# WIDFIELD WSD EL PASO COUNTY, COLORADO GRADING AND EROSION CONTROL PLANS

GRADING AND EROSION CONTROL PLANS  
WIDFIELD WSD  
NORTHERN UPPER E. TO W. TRANSMISSION MAIN  
WATER MAIN REPLACEMENT PROJECT  
EL PASO COUNTY, COLORADO

Issued 09/14/22

issued	11/27/22

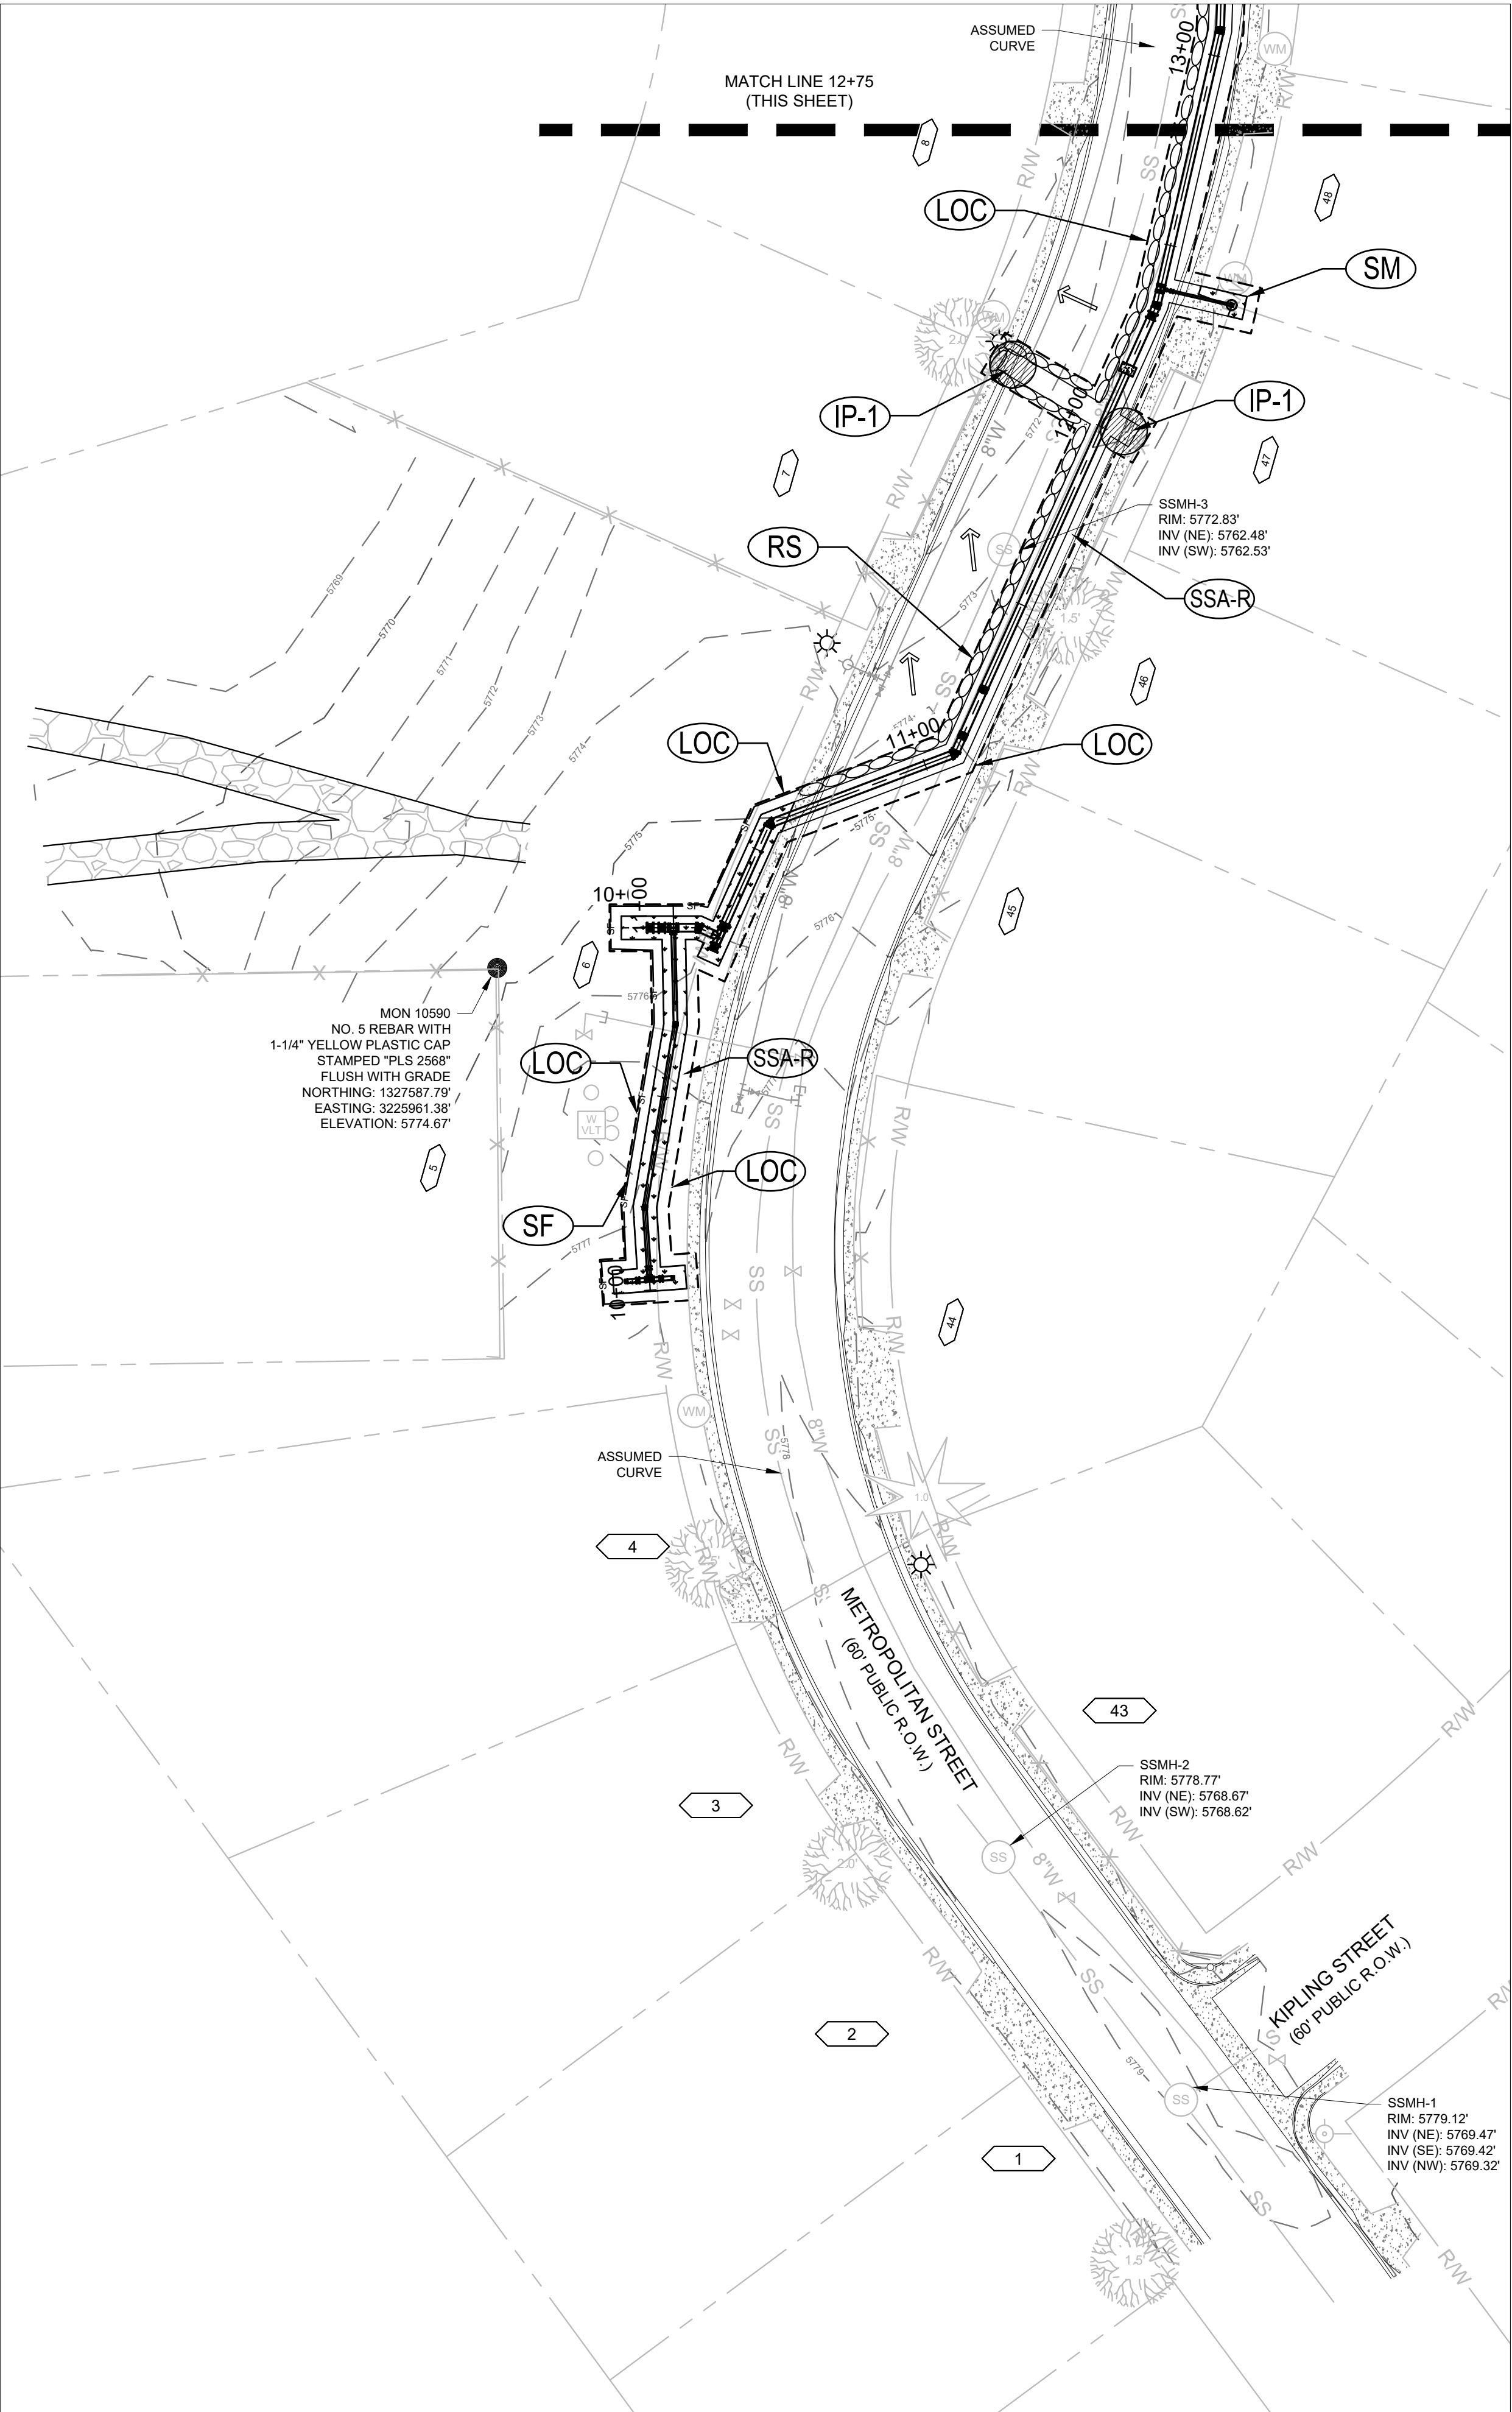
Please show all easements where the proposed waterline is to be in private property on all sheets.
